A12 Chelmsford to A120 widening scheme

8.16 Statement of Common Ground with Witham Town Council

Statement of Common Ground with Witham Town Council

STATEMENT OF COMMON GROUND

Map Book 3: Replacement Land, Witham

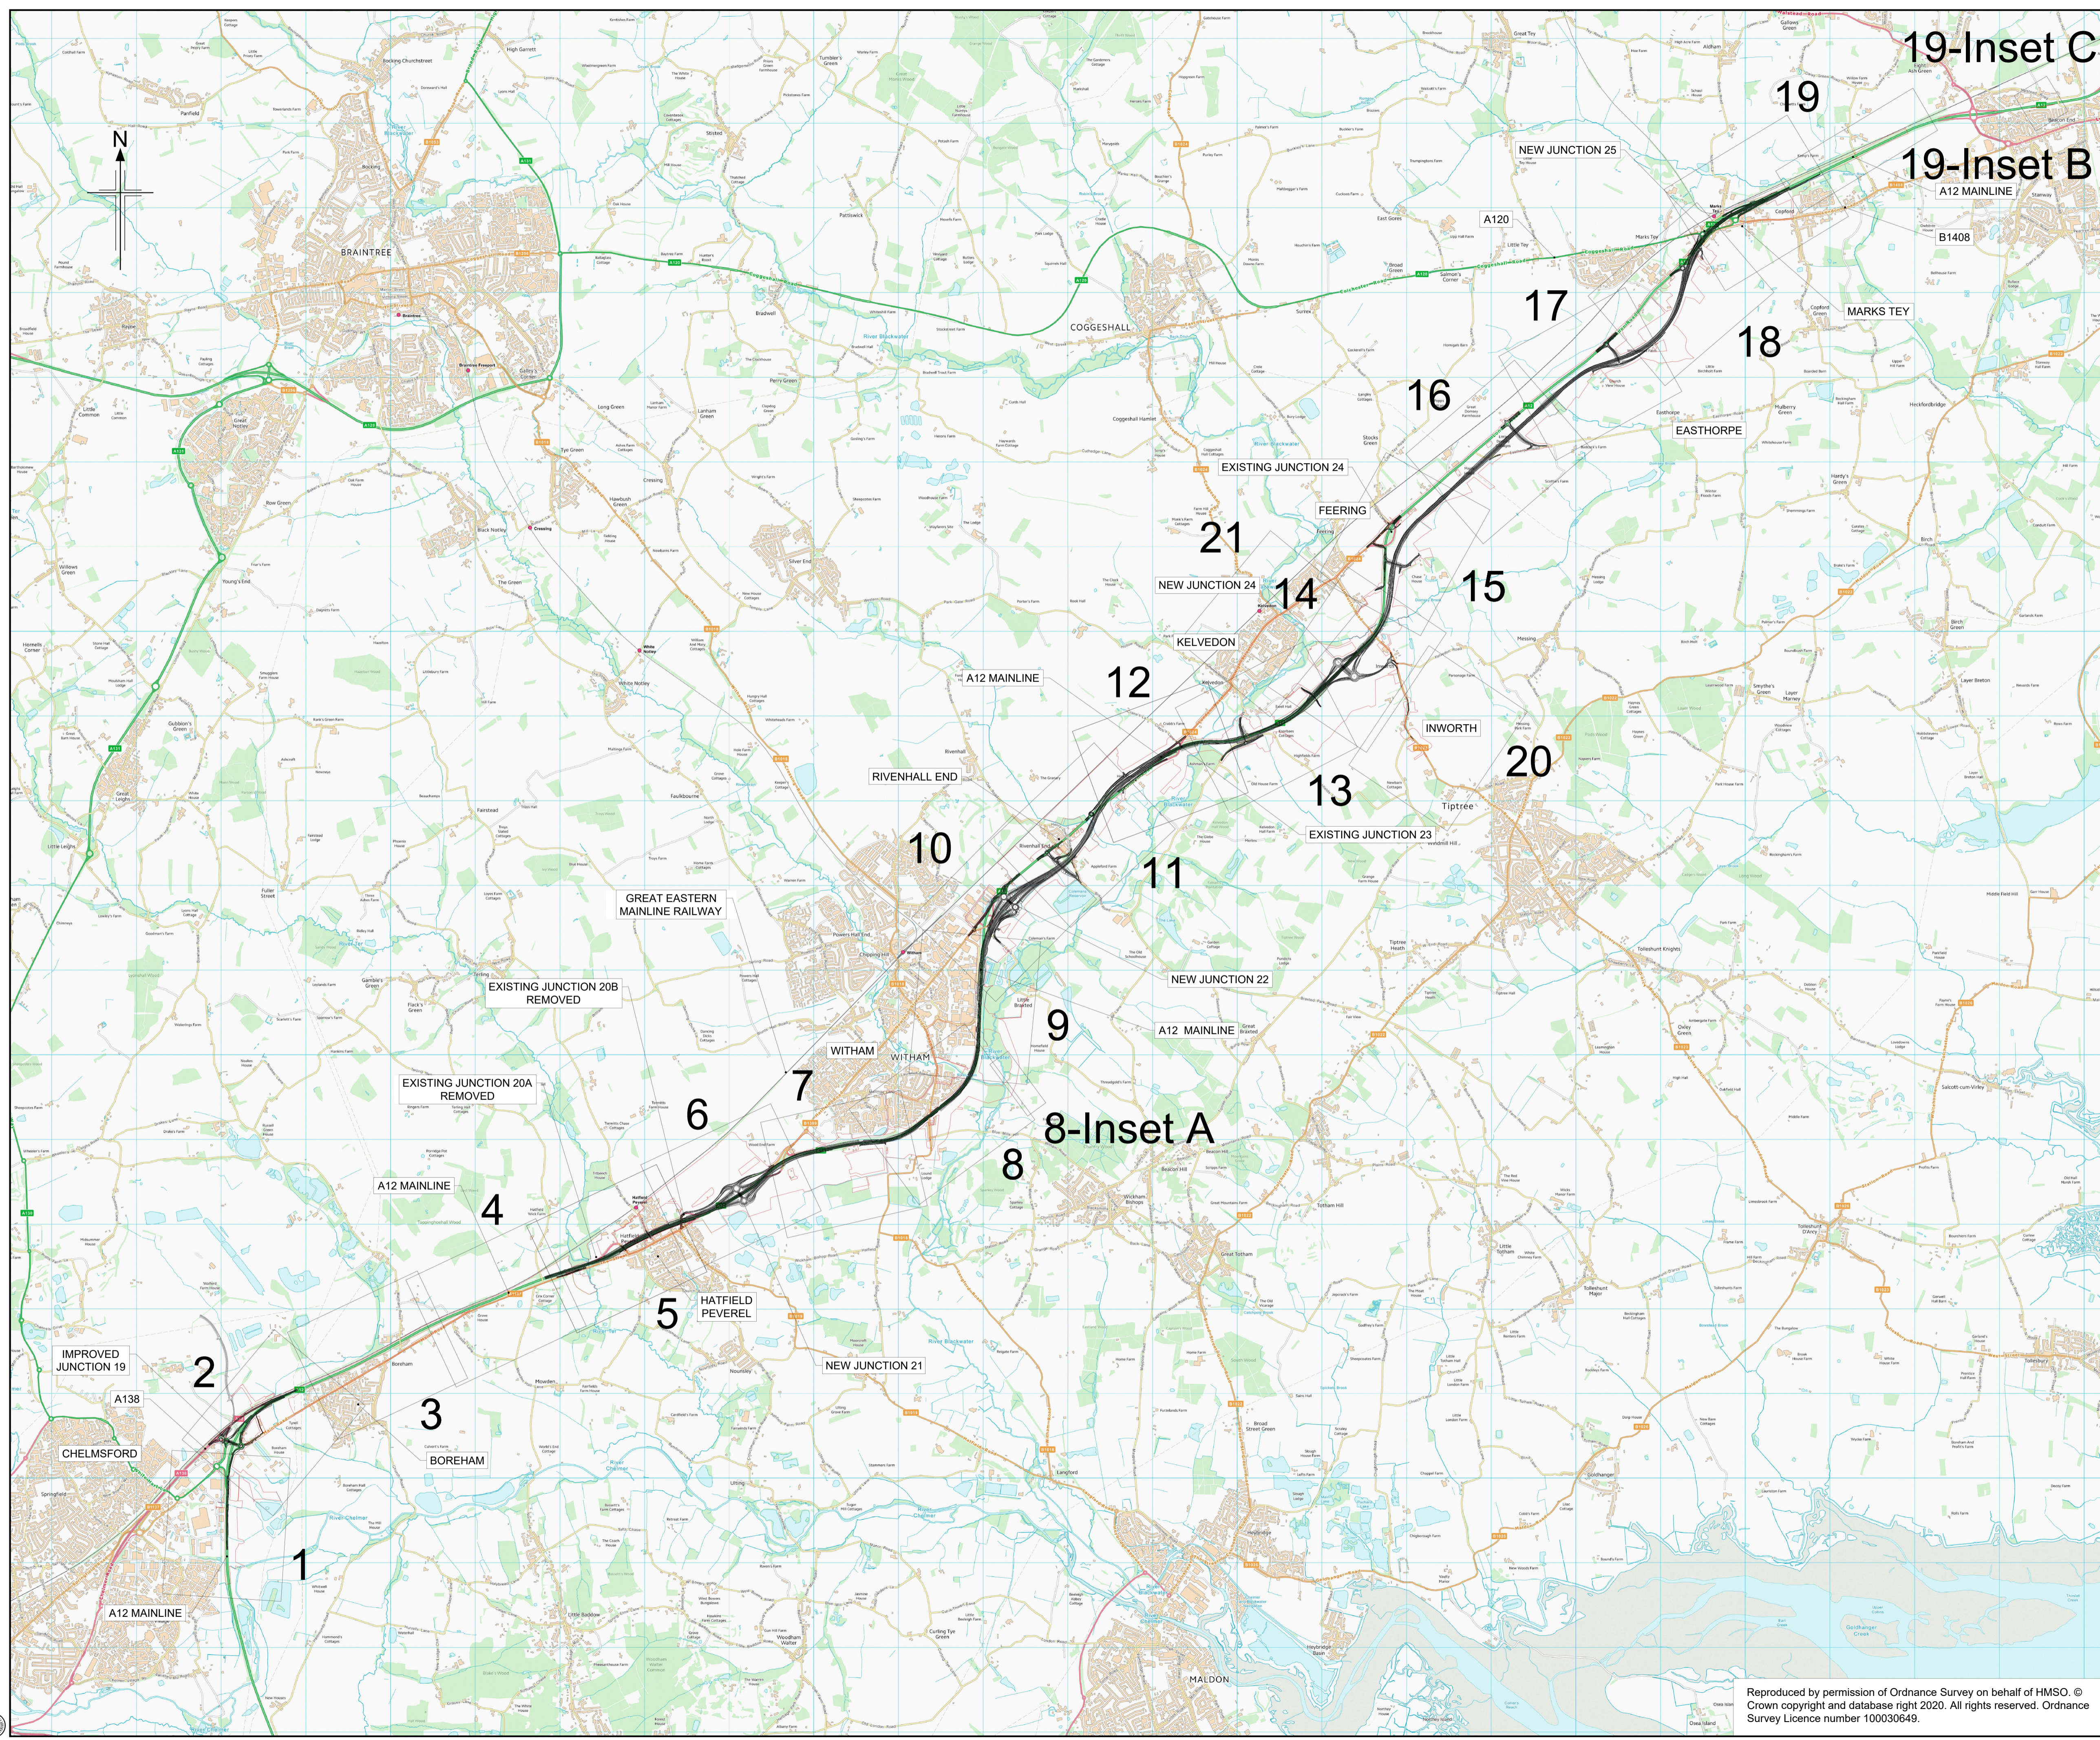
Ref	Issue	Doc Reference	Witham Town Council Position	National Highways Position	Status	Date
	Replacement Land is Inadequate for a Nature Reserve	Statement, Chapter 9, Biodiversity [APP-076] Environmental Statement, Figure 2.1 Environmental Masterplan Part 1 [REP6-043]	<i>is inadequate for a nature reserve. Concerns include required access and maintenance to make the area as enjoyable to the public.</i> <i>WTC are happy with the newly proposed replacement land, subject to plot 8/45f being accepted into examination in place of plot 9/1h.,</i>	replacement land as close to the loss of the existing open space as is practicable. National Highways proposed replacement land as shown in the Replacement Land Statement [REP6-056] within Sections 2.1.25 - 2.1.27, and Plate 2.7 Open Space Areas 9 and 10. The parcels identified are both currently woodland adjacent to the existing A12 and would replace the existing woodland strip adjacent to the A12 in the Whetmead Nature Reserve. The plots identified as replacement land for Witham Town Council either border the existing Whetmead Nature Reserve or connect with an existing Public Right of Way (PRoW). Witham Town Council have expressed that plot 9/1h is inadequate as replacement land. On 30 May 2023, National Highways submitted a Change Application requesting that the Examining Authority consider accepting six changes to the Scheme into the Examination of the DCO application. One of those changes relates to the provision of replacement land at Whetmead. The replacement land now

Ref	Issue	Doc Reference	Witham Town Council Position	National Highways Position	Status	Date
				proposed is near to the existing Whetmead Local Nature Reserve, plot 8/45f, and is shown in Development Consent Order Change Application, Map Book 3 – Replacement Land, Witham – Part 1 of 1 [AS-076]. This replaces the originally proposed plot 9/1h. National Highways will work with Witham Town Council to develop a suitable landscaping design and access design.		
3	Slow Moving Vehicles banned on the A12 and the alternative route through Witham Town Centre		<i>Understanding that agricultural traffic will not be permitted on the A12 and the implications this will have on Witham town centre traffic</i>	<p>National Highways has undertaken a safety risk assessment that documents the safety impacts of Slow Moving Vehicles (SMVs).</p> <p>National Highways does not believe the volume of SMVs is such that it is inappropriate for use around the current route around Witham without current weight restraints.</p> <p>National Highways has requested information from National Farmers Union as to the number of SMVs that may be expected to travel on the local highways instead of the A12. Feedback is that this volume of traffic would be limited to a small number of vehicles. National Highways does not believe it is proportionate to amend the existing environmental weight restriction through the Town Centre but will</p>	Agreed	31/05/2023
